Re: Armar Road Townhomes – *Technical Review 1*
PA22047

RE: Armar Road Townhomes, File# PA22-047
17 unit townhome development
6506 Armar Road & Parcel # 30052800402700

To: Elden McCall, Mac Engineering
From: Don McGhee, Assistant Fire Marshal
Date: March 23, 2023
Subject: PA22-047 6506 Armar Rd. Townhomes

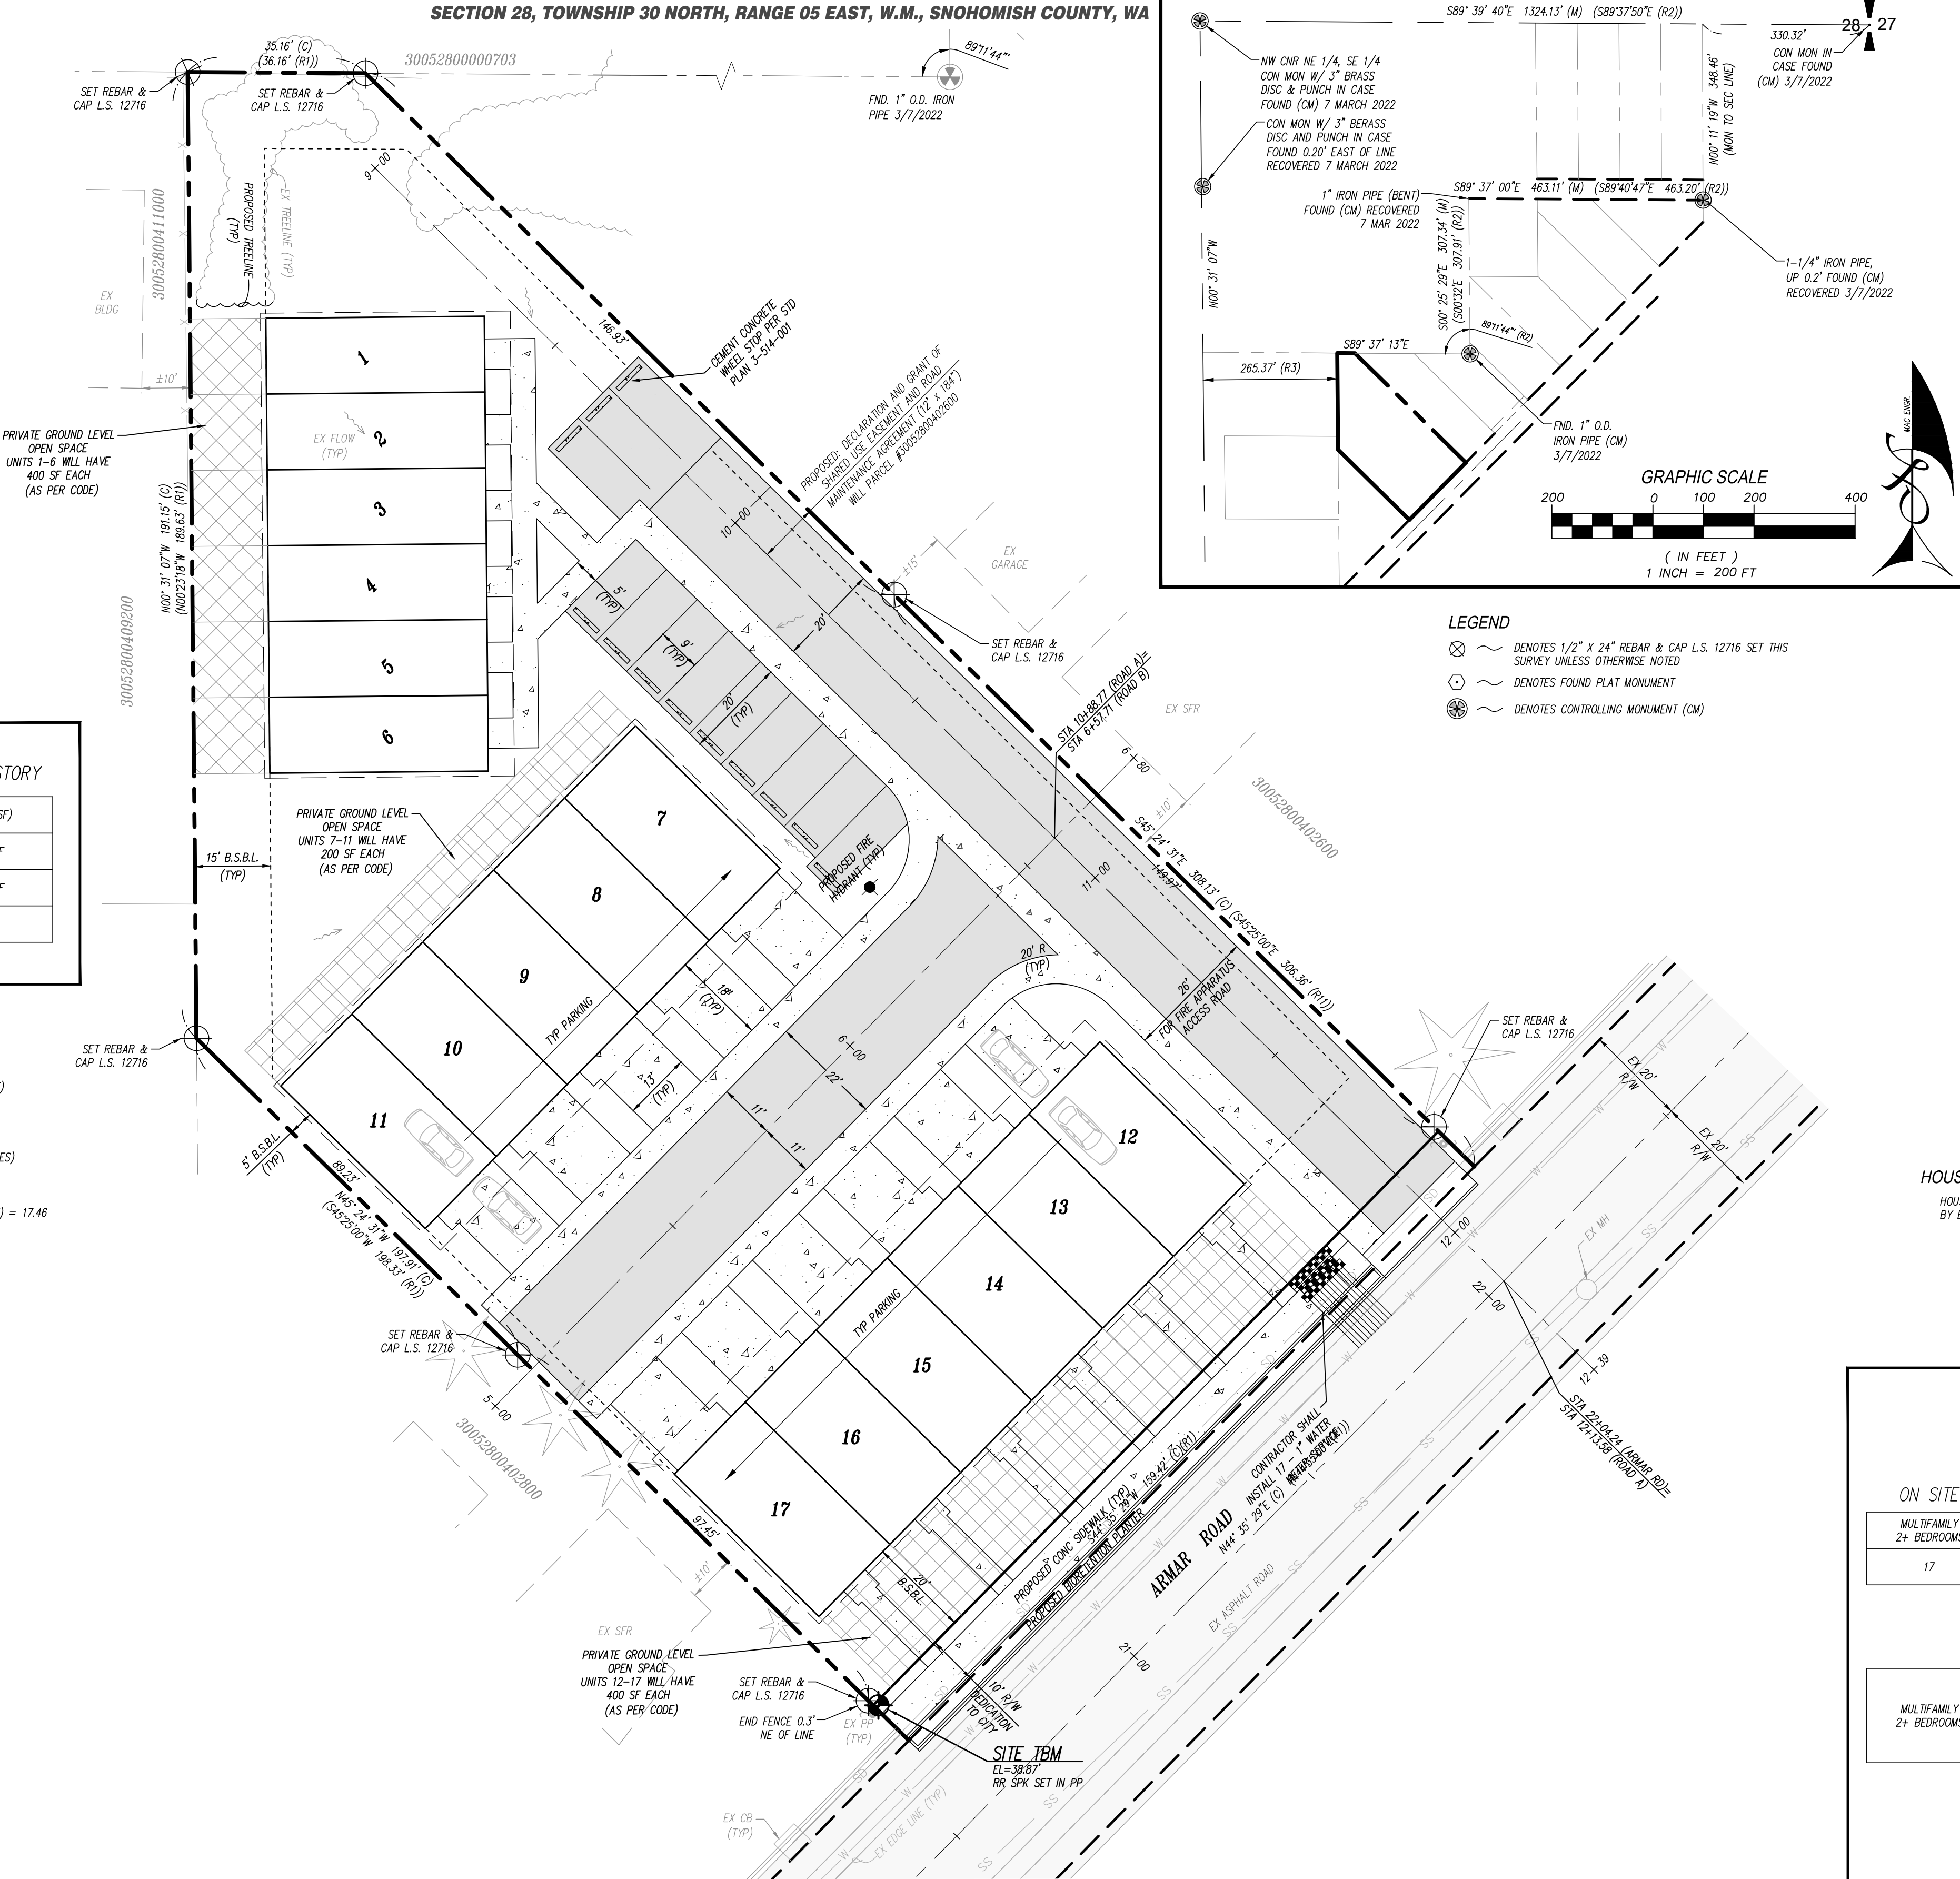
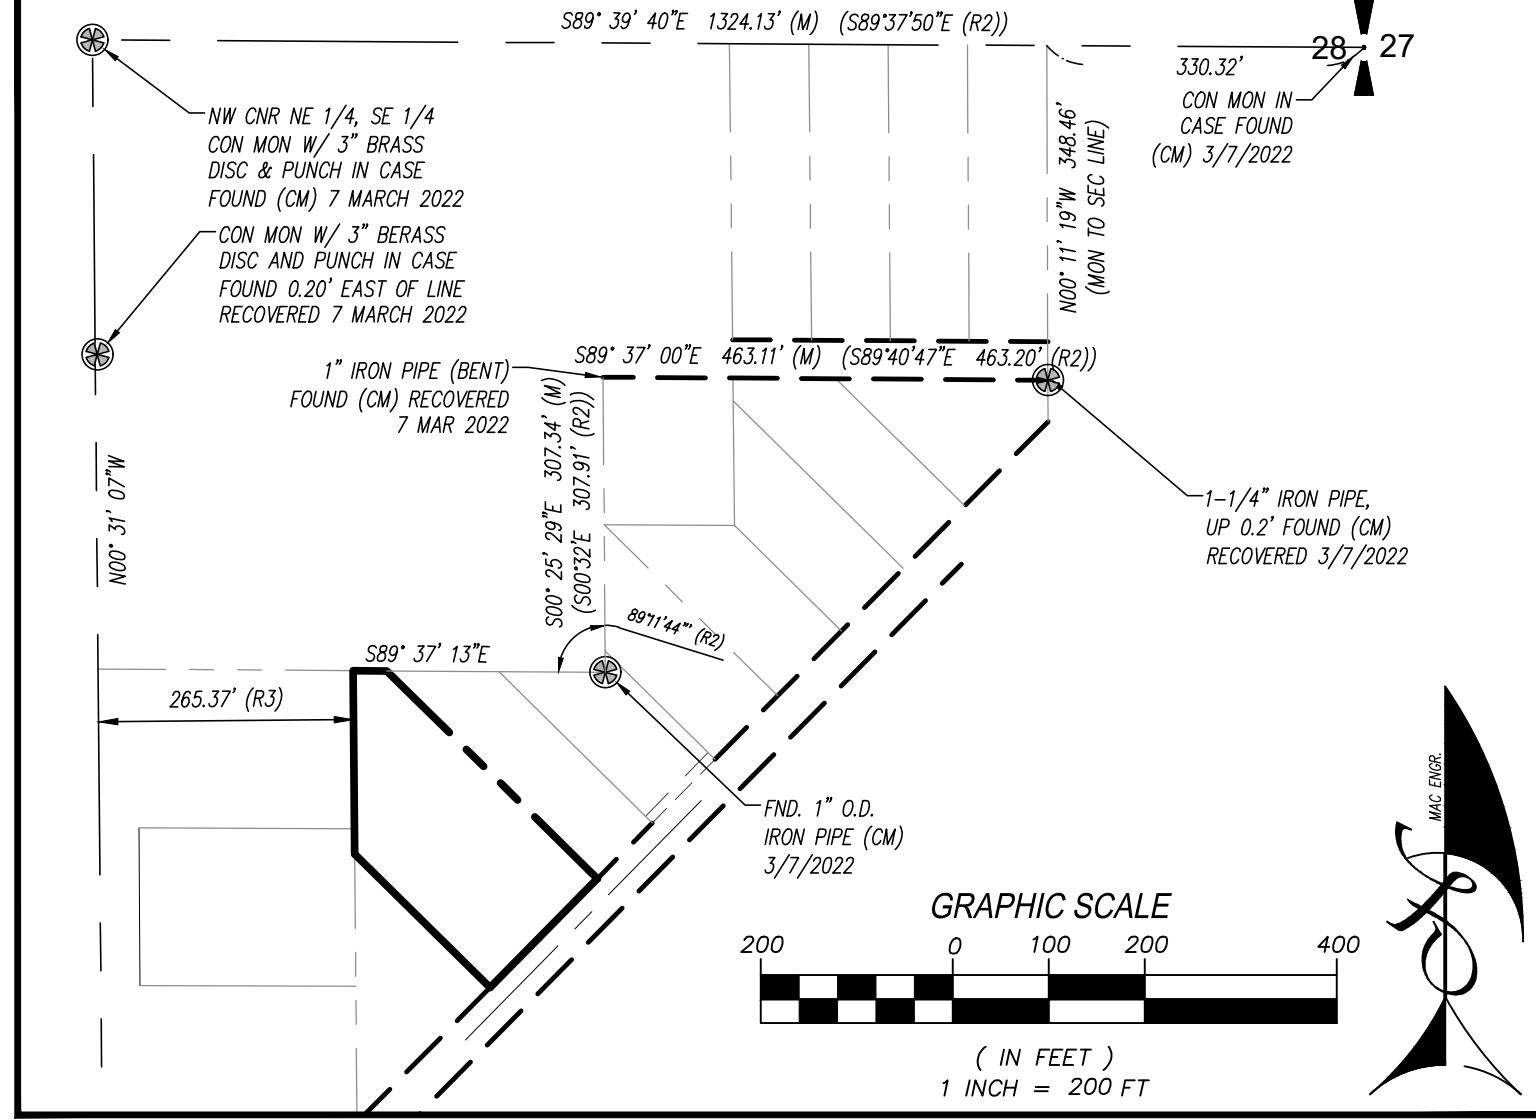
- d. The required road section for townhomes is 22' of asphalt then the gutter section for rolled curb, giving us a 24' wide driving surface. This applies to both Road A and Road B.

11. Access planned appears adequate for fire apparatus. Access of 20-22' wide is shown on the plan. A minimum 20 feet wide fire apparatus access road is required. A minimum 26 feet wide fire apparatus access is required in the immediate vicinity of any building more than 30 feet in height for ladder truck operations, and within 20 feet on both sides of fire hydrants.

12. Access planned appears inadequate for aerial fire apparatus access. Access of 20'-22' wide is shown on the plan. A minimum 26' wide fire apparatus access is required in the immediate vicinity of any building more than 30' in height for ladder truck operations, with the near edge of the access located within 15'-30' of the building, positioned parallel to one entire side of the building (MMC 9.04.503.1.4).

19. Plans show a 20' drive aisle. A 26' wide paved access may be required due to hydrant access requirements, and/or building exceeding 30' tall (building heights not provided). Approved fire access is required. Rolled curbing or no curbing sidewalks can be used to meet this requirement.
